Thank you for your enquiry with regard to your proposed approach to the DCO and Works Plans. See below comments on the approach you set out which expands on the advice provided by the Planning Inspectorate under section 51 of the Planning Act 2008 in our previous meetings.

Work No1 within the draft DCO would be worded as set out as “Work No 1 – An electricity generating station (the K3 Generating Station) with a gross installed generating capacity of up to 75MW.”

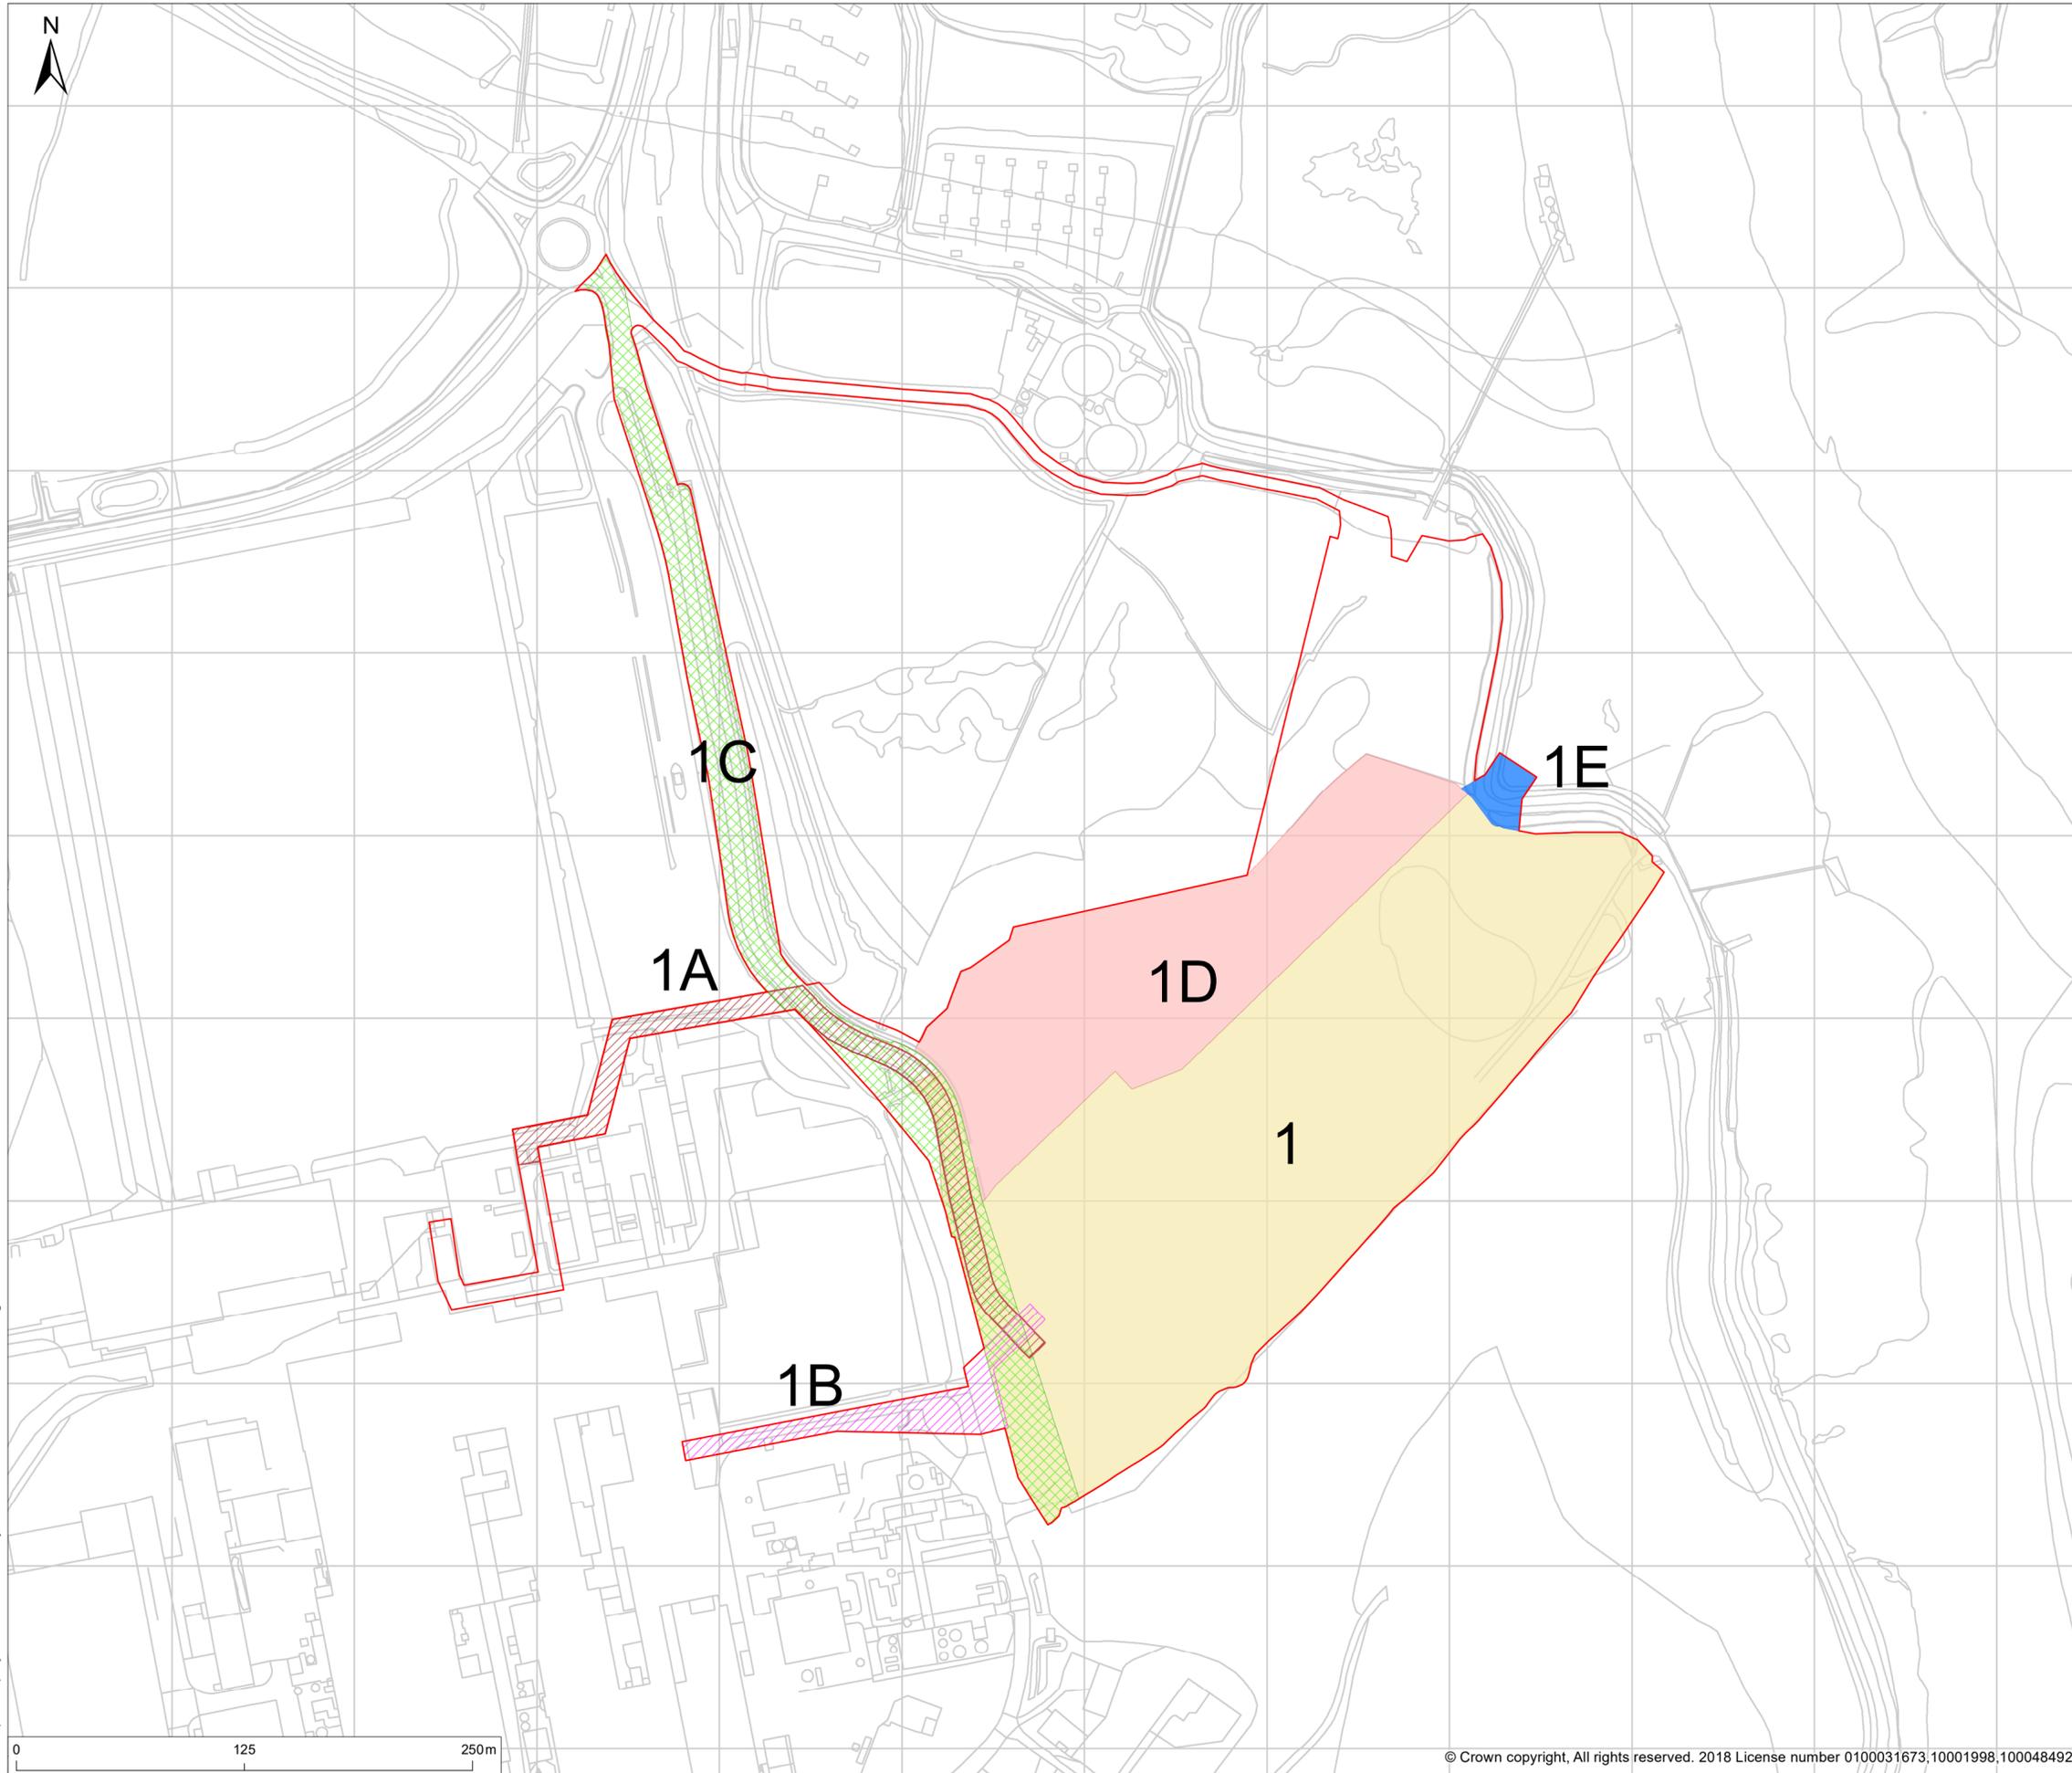
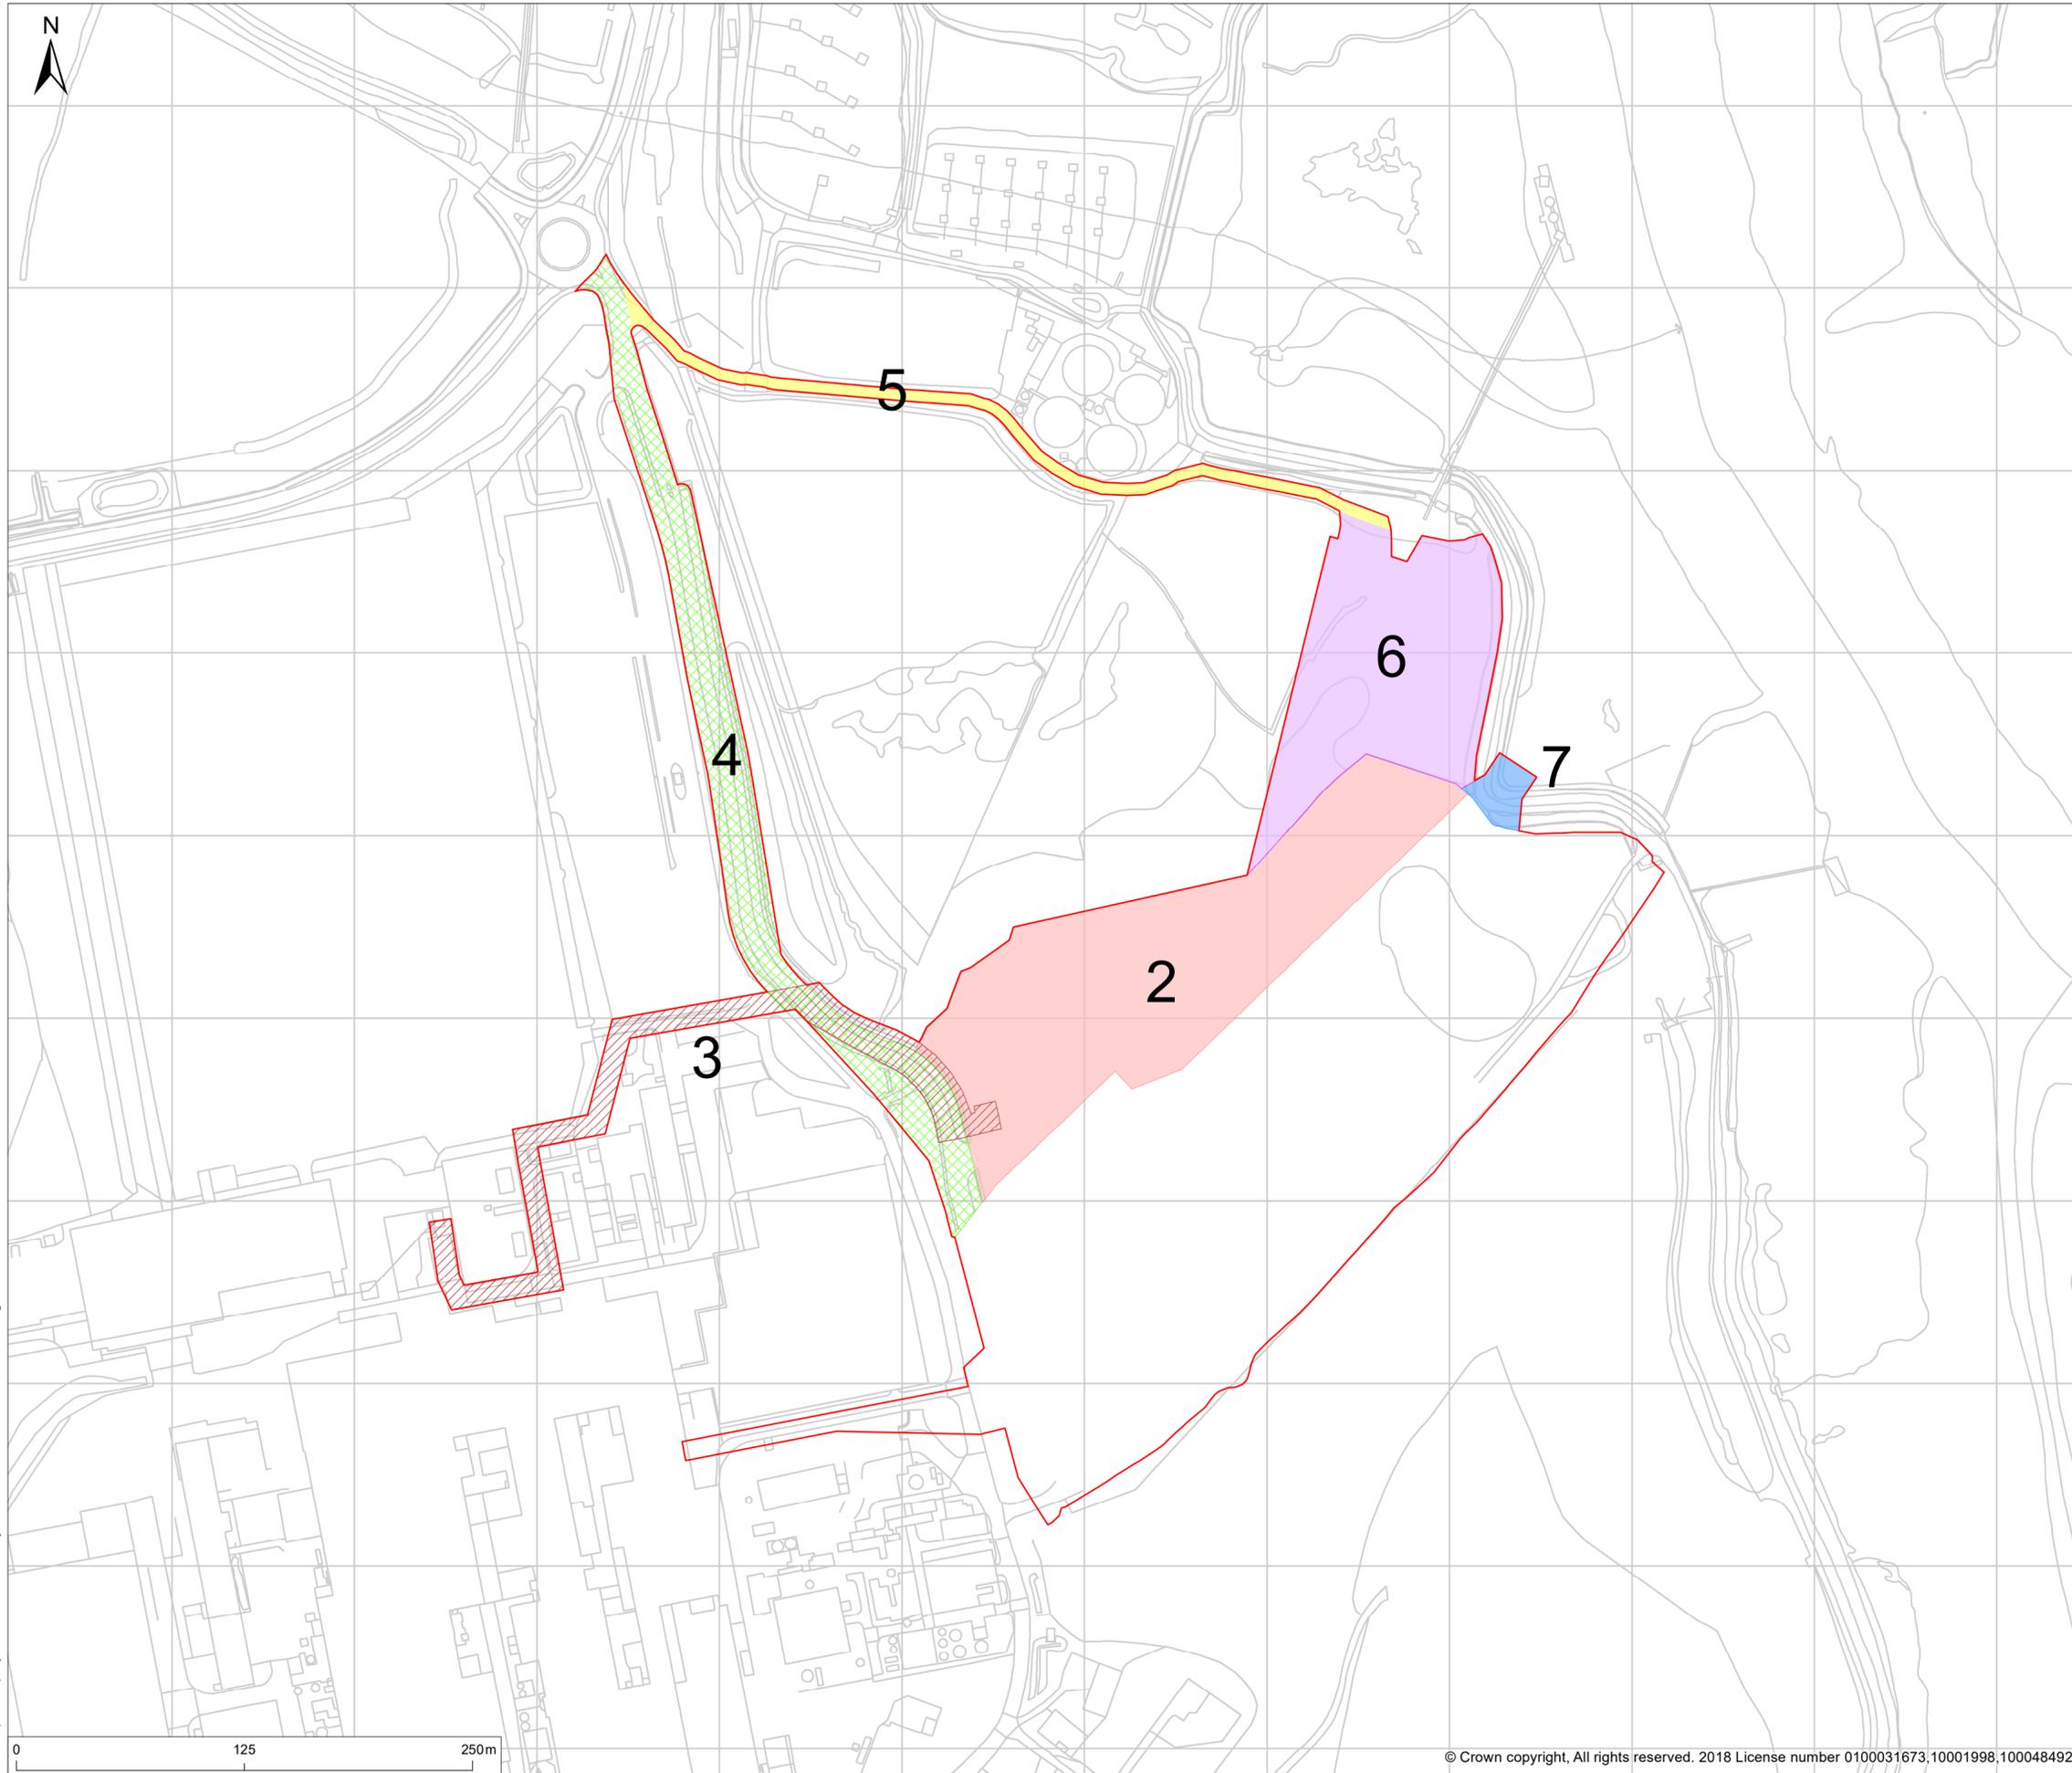
The Works Plan would remain as per the attached, which is the plan on which the previous 2018 consultation/publicity was based, and the extent of Work No1 would remain the K3 facility itself.

Any works referred to in the draft DCO, for which development consent is applied for, would need to be shown on Works Plans. See comments above.
